Our Ref: PD/2755
Your Ref: FG/159/18/PL

6th November 2018

Two-storey extension to the existing Cafe in order to provide increased internal seating, multi-purpose space, with improved service & food preparation area, disabled access & bike storage at The Bluebird Café, South Drive, Ferring, BN12 5QU
Council Ref: FG/159/18/PL

02  
2002  
PROPOSED FIRST FLOOR PLAN  
Scale: 1:100

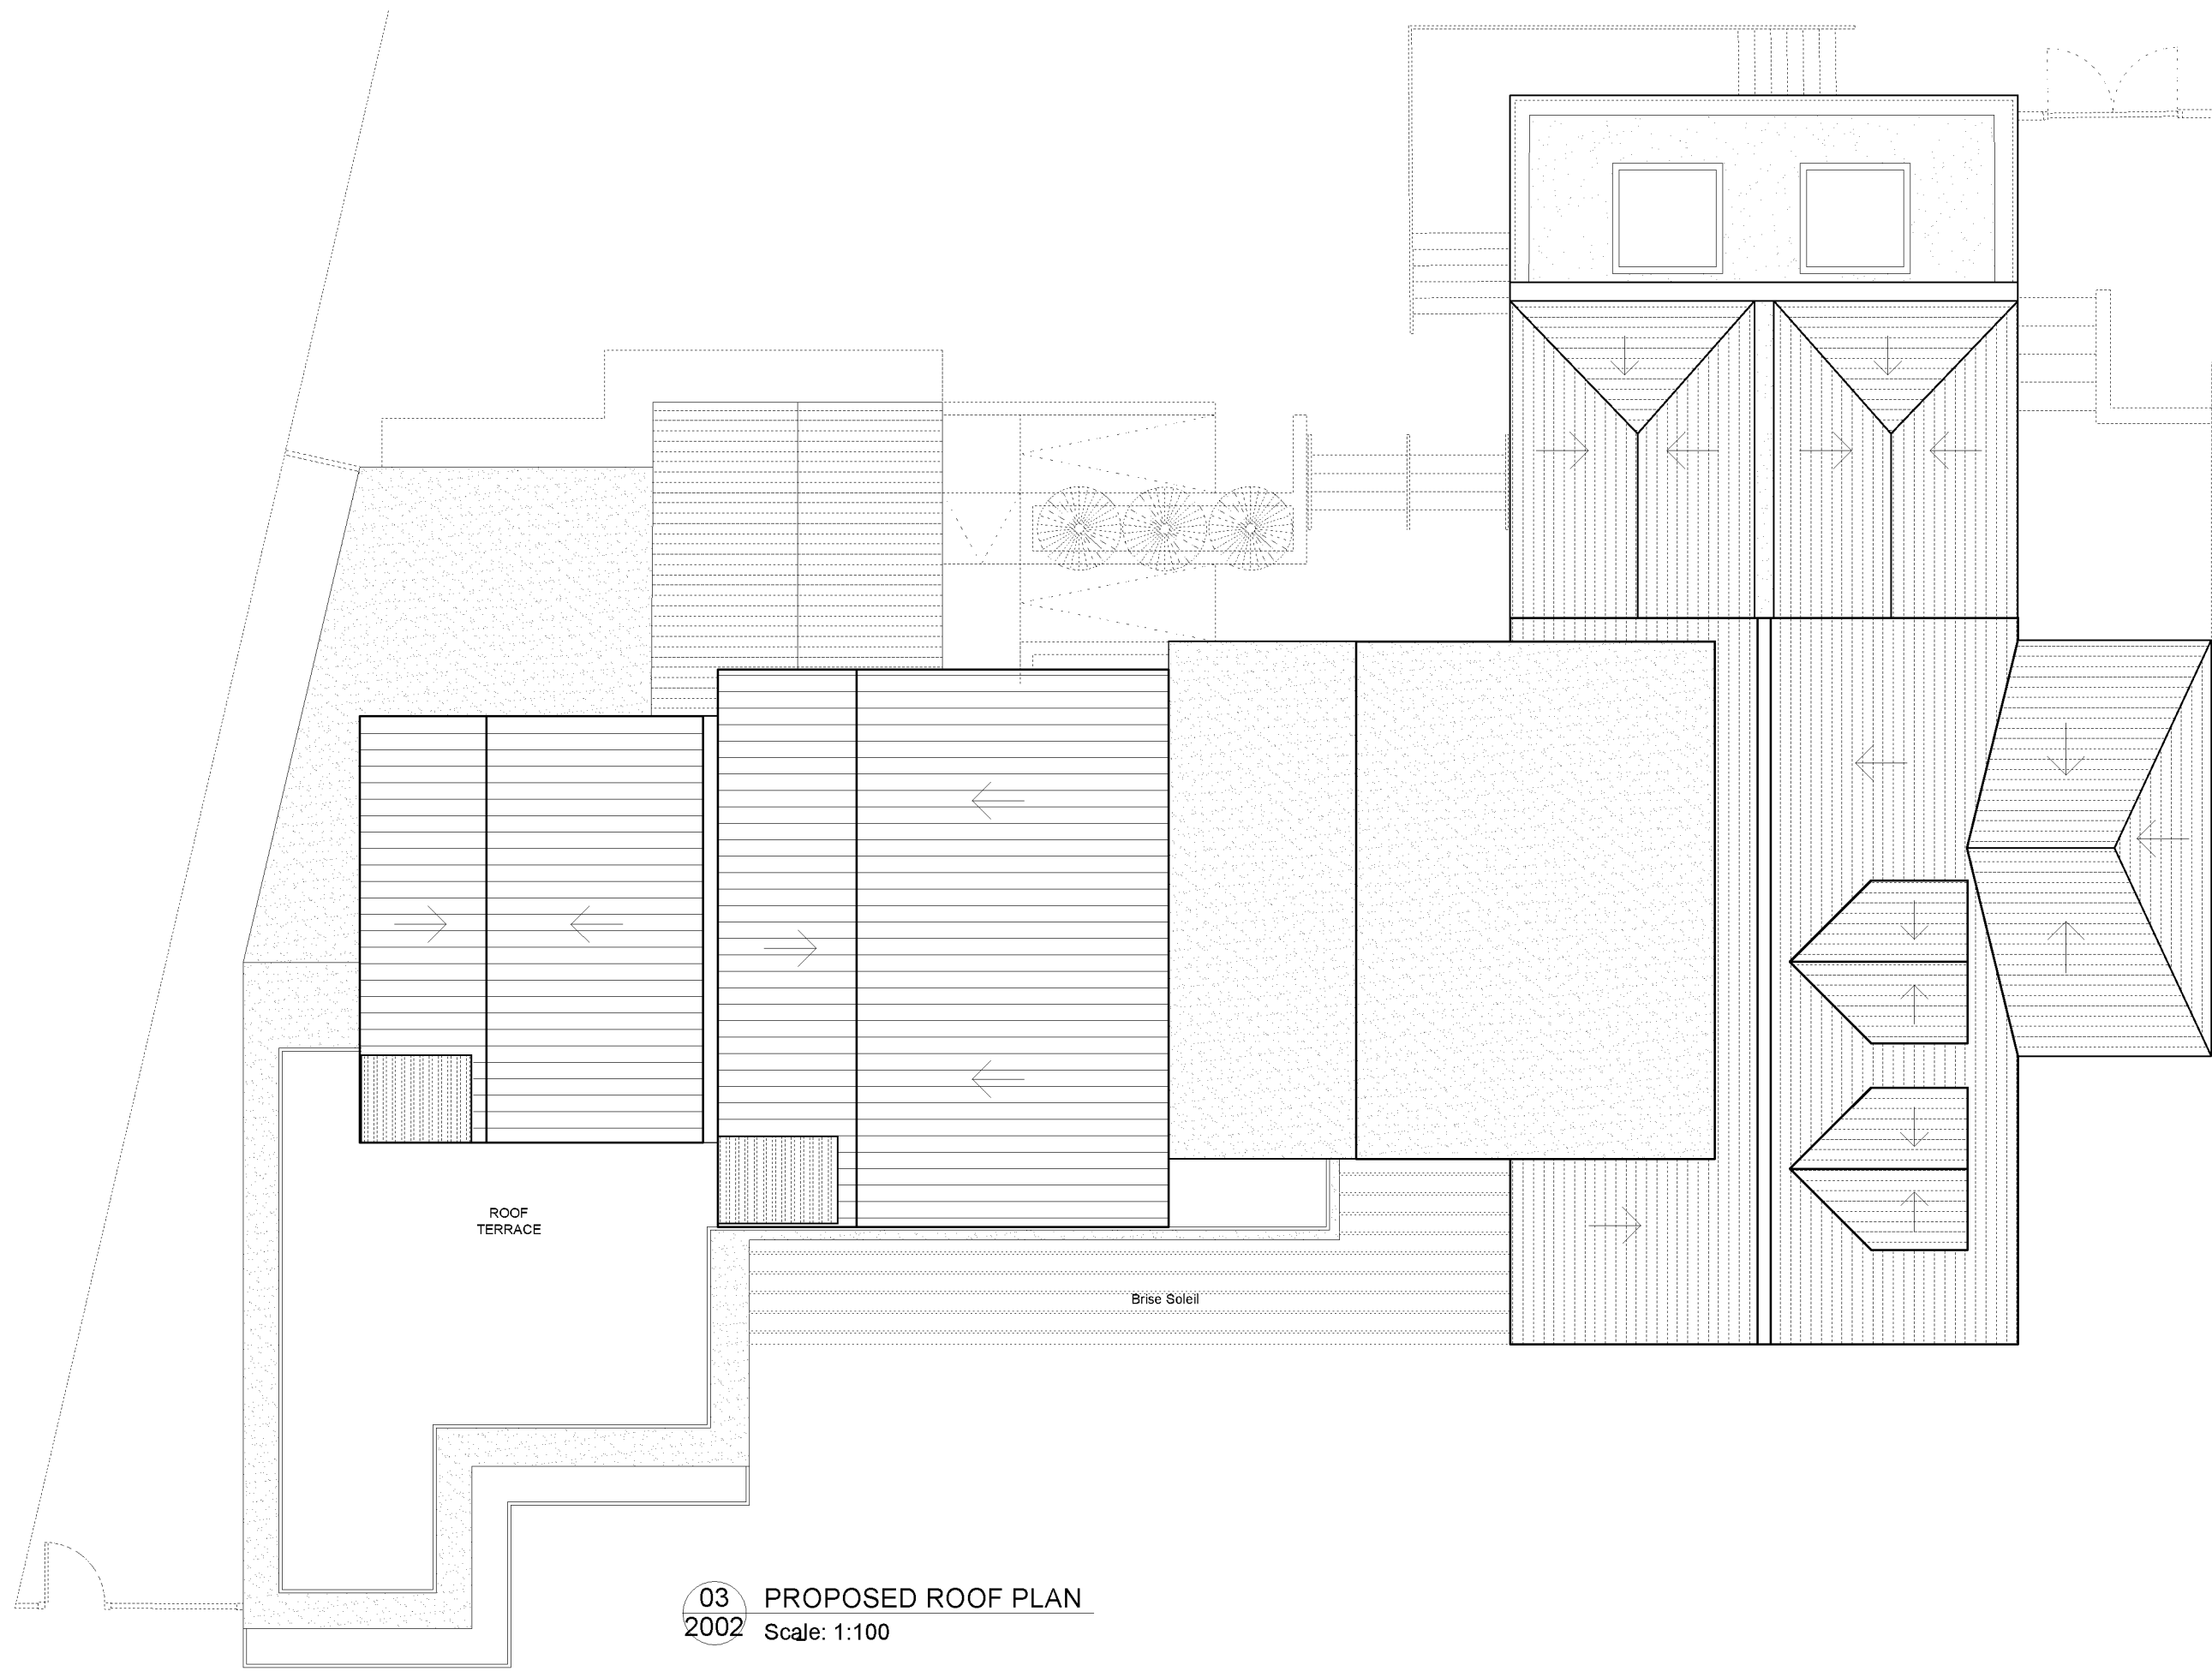
In addition, there would be a loss of residential amenity through overlooking resulting from the large terraced area. This is shown on drawing no. BCA200301 and indicates a large expanse of terrace at first floor level which would afford users of the café a birds eye view into the garden area of 'Neptune'. It features what the plans describe as a "balcony glazing system". The people depicted on the plans tower above the "balcony glazing system" and it will do nothing to ameliorate the significant adverse impact of overlooking on 'Neptune'. If the Council is minded to approve the terrace area it should feature 2 metre high privacy screen on the north and west elevations to protect the amenity of 'Neptune', although this approach would do nothing to reduce the adverse impact of noise from the terrace as we explain above.
